10 Island Street

I thank you all for responding to the emails from concerned neighbors of the 10 Island Street building proposal. There are still questions that have not been answered.

1 WEST ELEVATION
 SCALE: 1/4" = 1'-0"

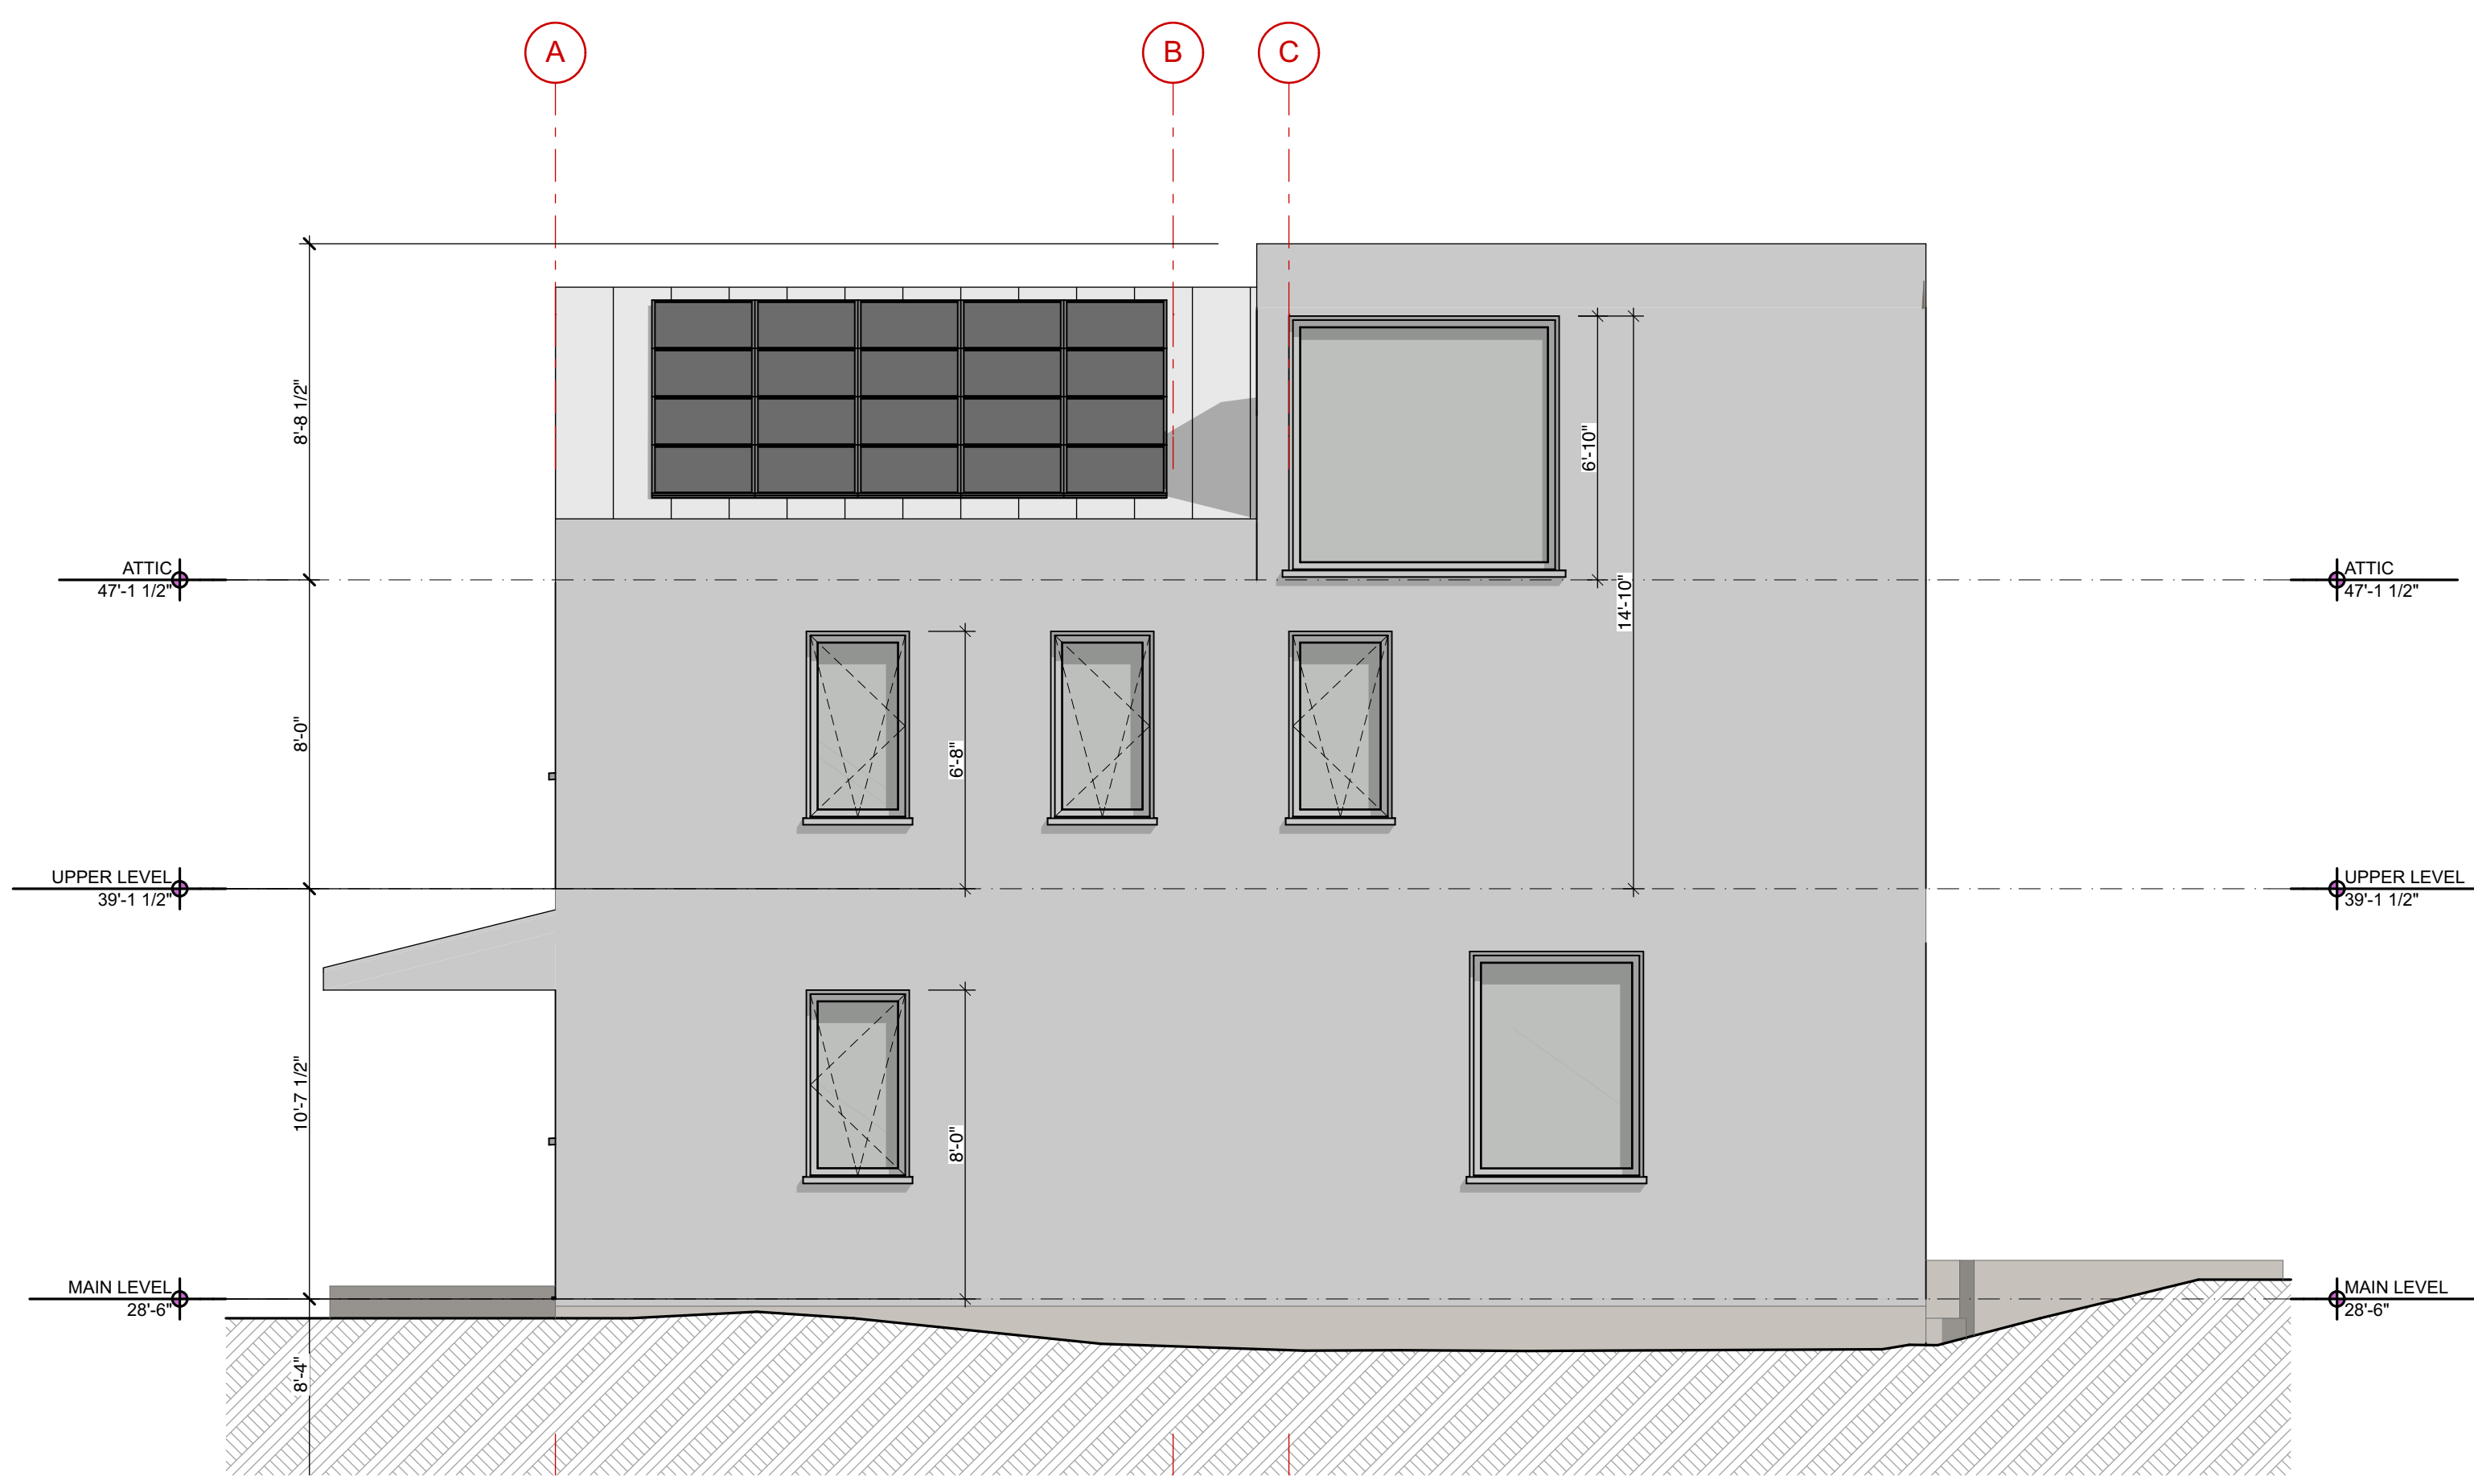
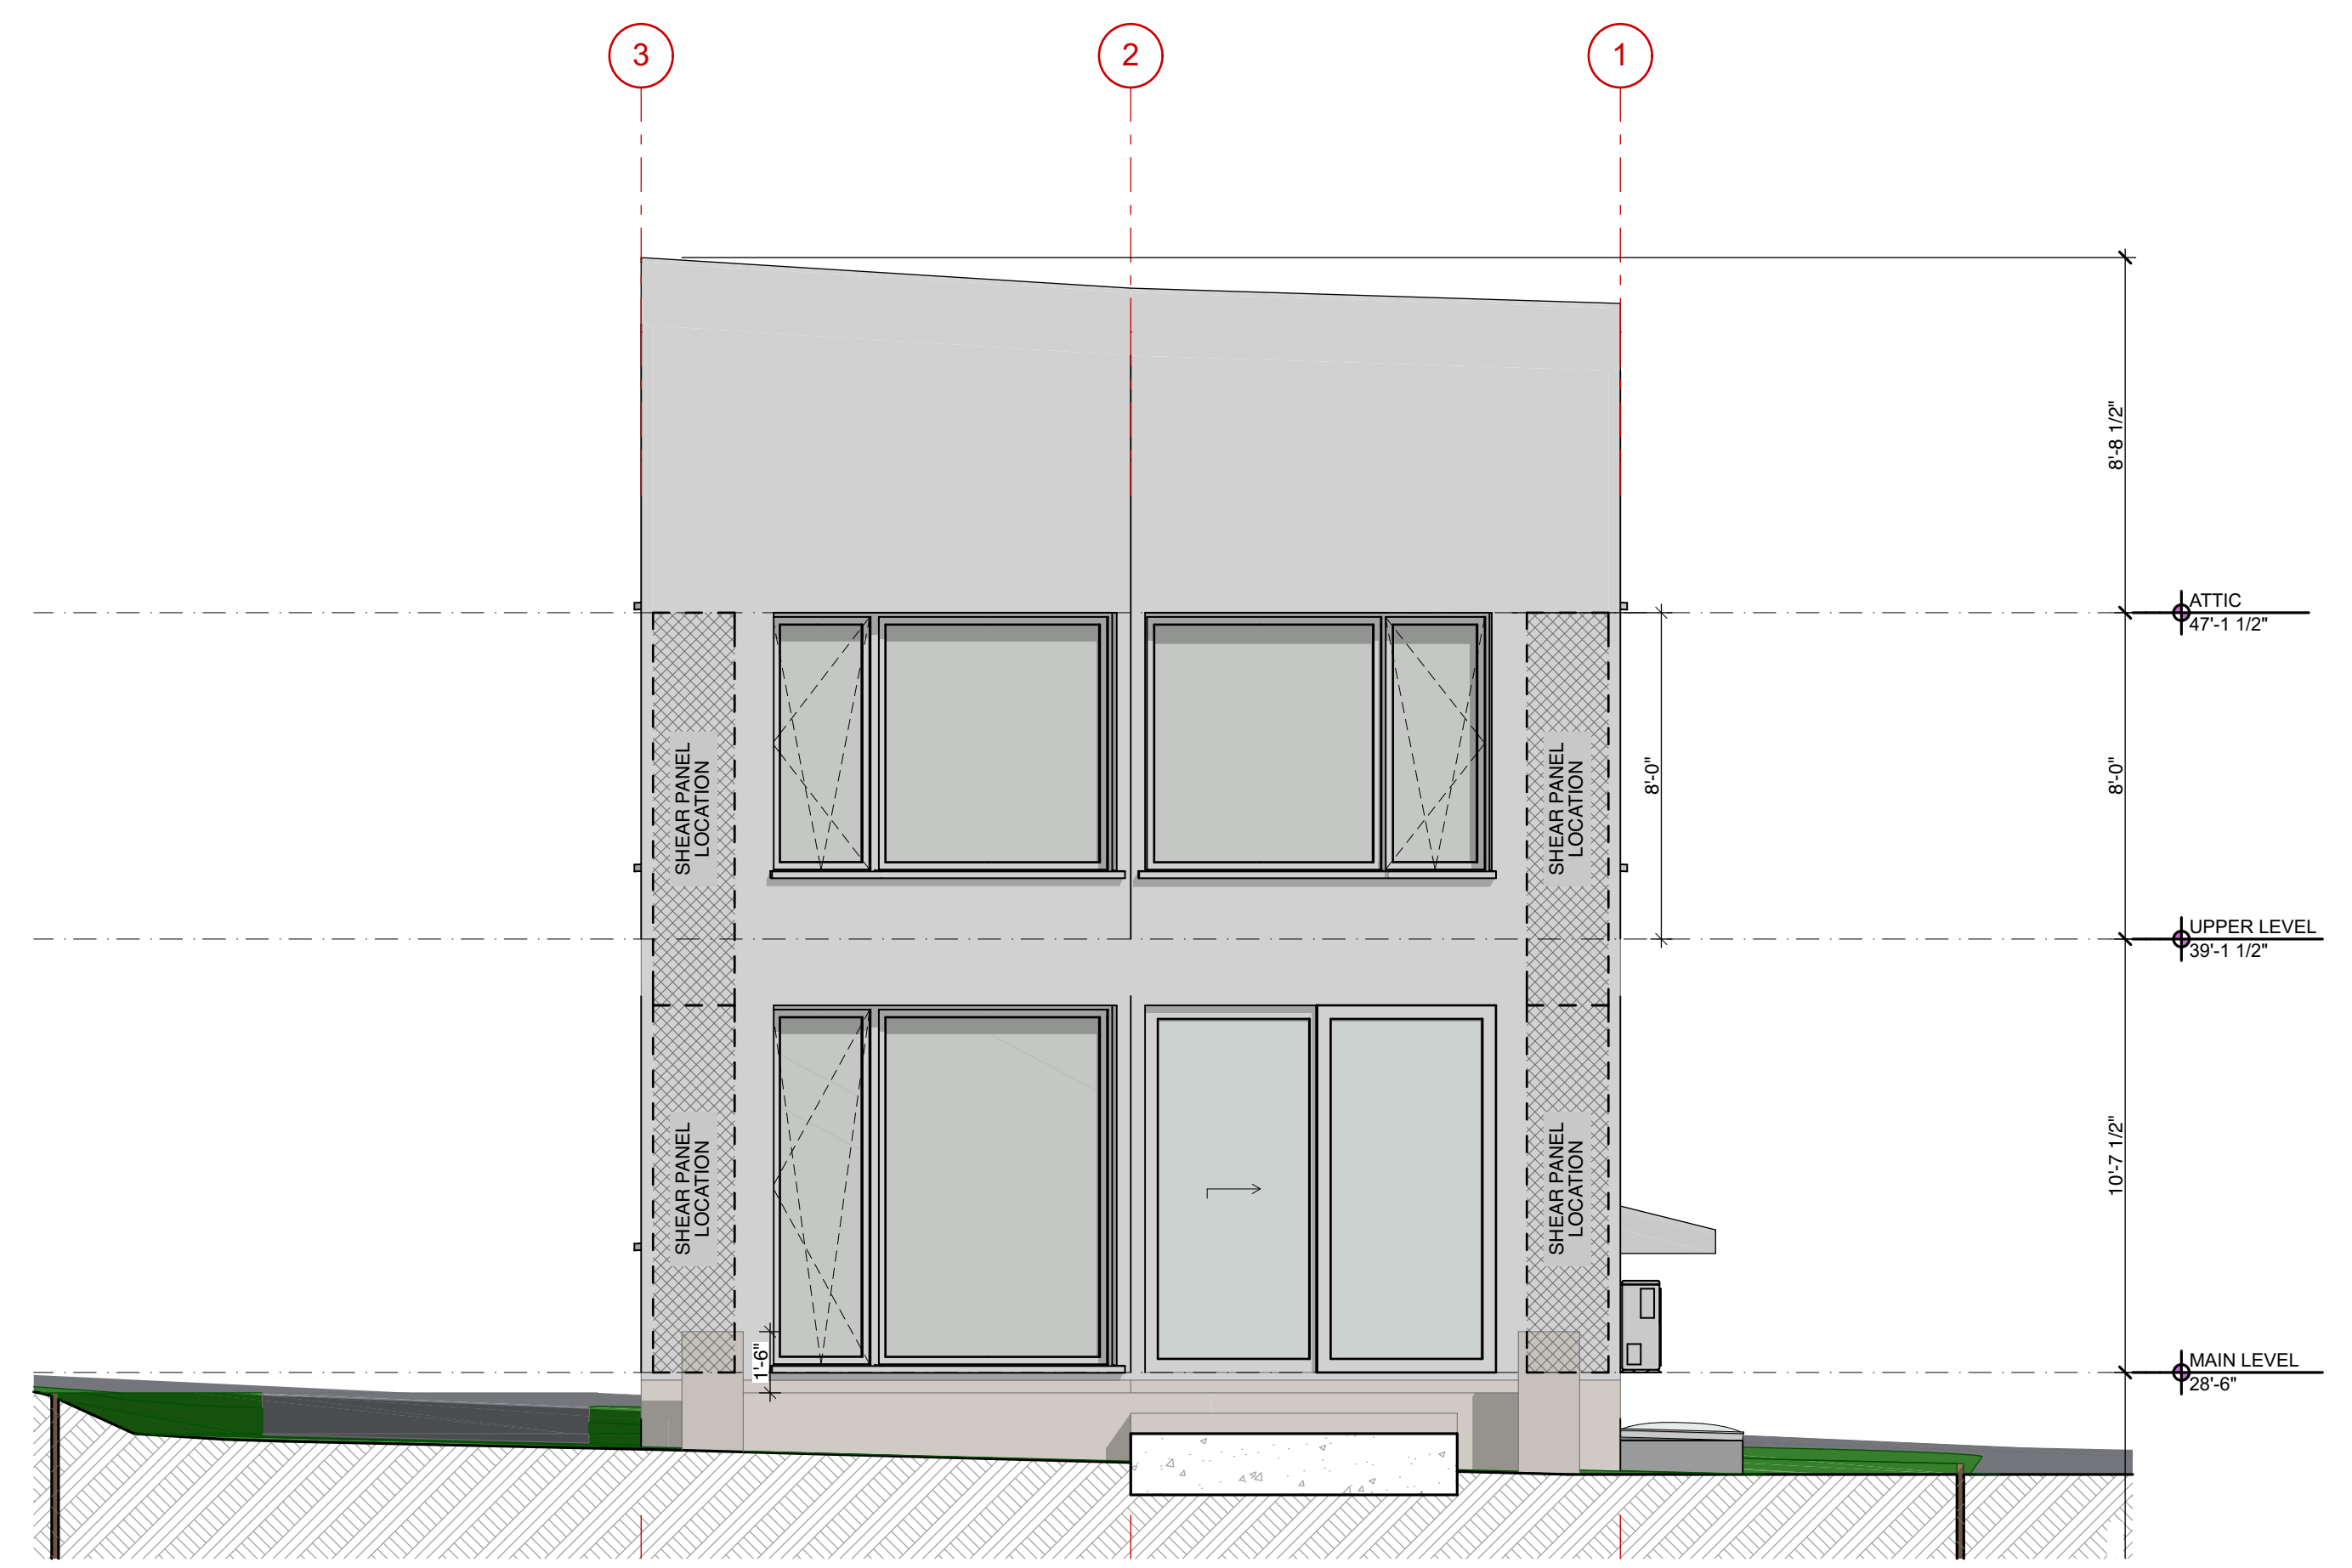
Another issue is simply that this proposed structure does just not fit in any way with the aesthetic of our little coastal neighborhood. We are a small residential community in Portland but tucked away between the sea and Interstate 295. Most of the houses are quaint clapboard and have been around for awhile. This obtrusive modern structure just does not fit here.

**BOUNDARY & TOPOGRAPHIC SURVEY**  
ON  
ISLAND STREET, PORTLAND, MAINE  
MADE FOR RECORD OWNER  
**DONALD PETERSON**  
74 WATSON STREET, PORTLAND, MAINE

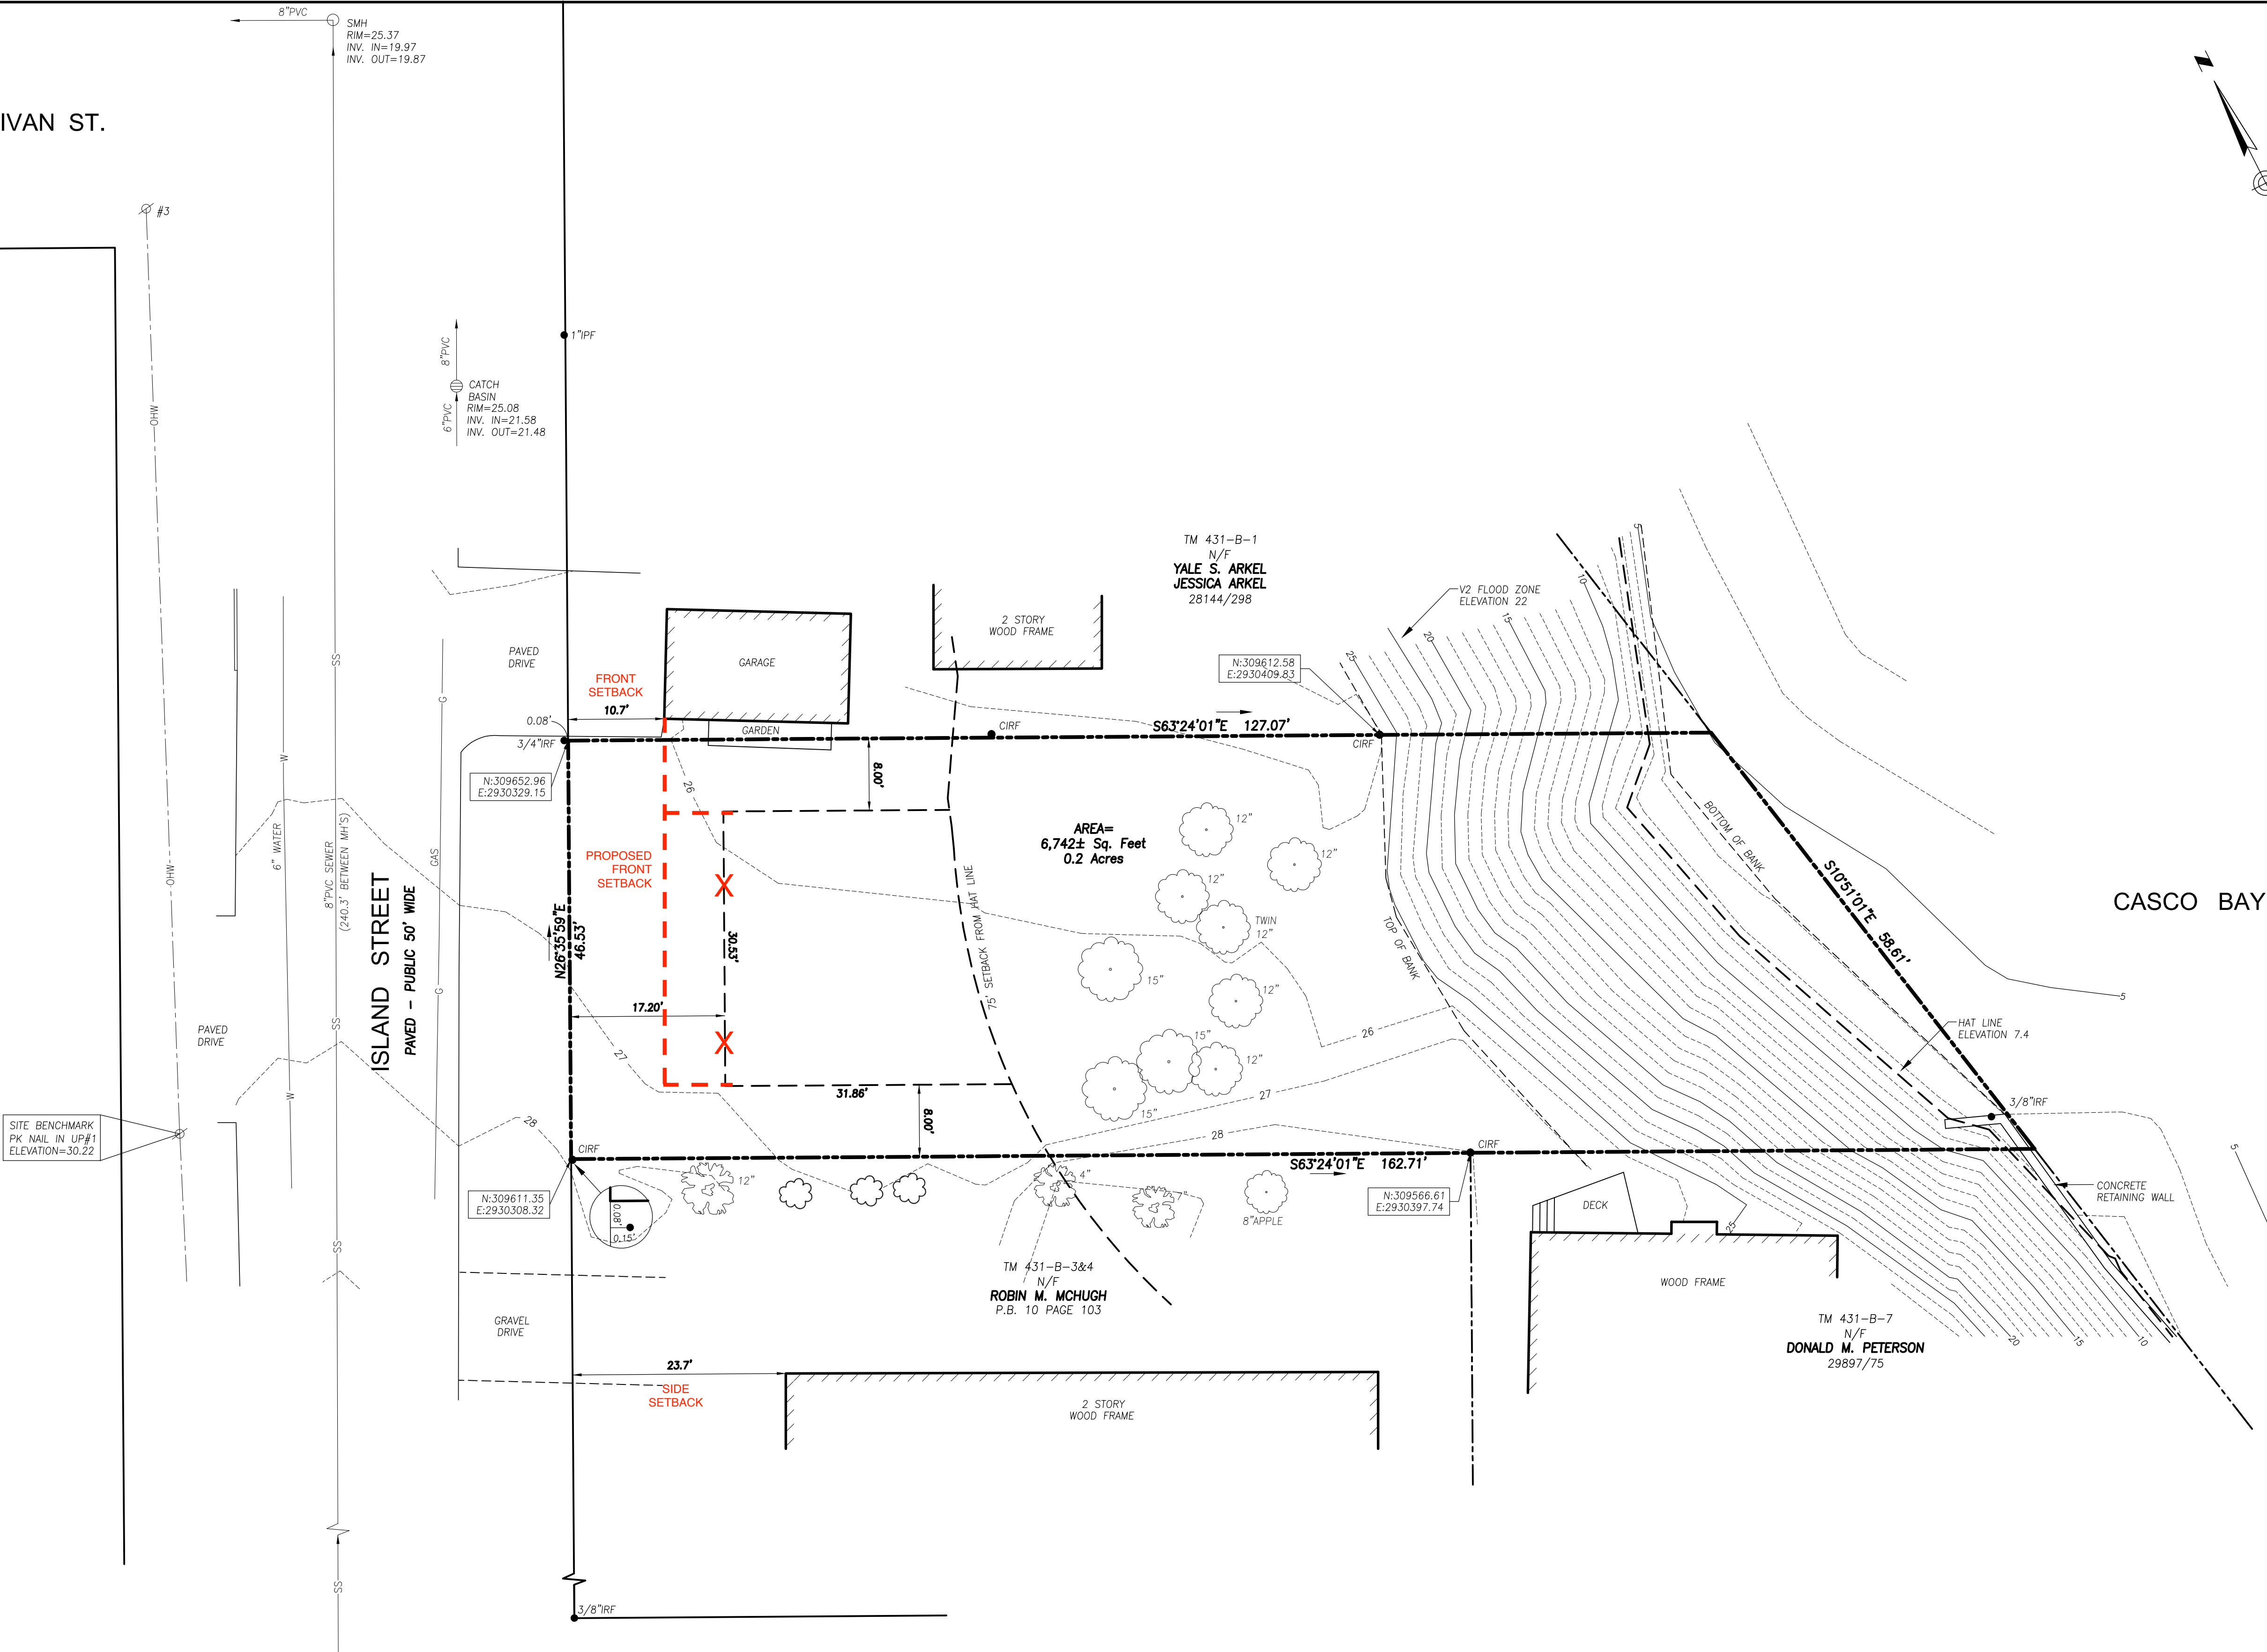
One of which is that the site plan does not accurately depict the 75 foot setback. This was done from a 2015 HAT line. It needs to be remeasured using the 2017 HAT which is higher than in 2015. The trend for the last 10 years shows the rising HAT line. This should be a huge consideration.
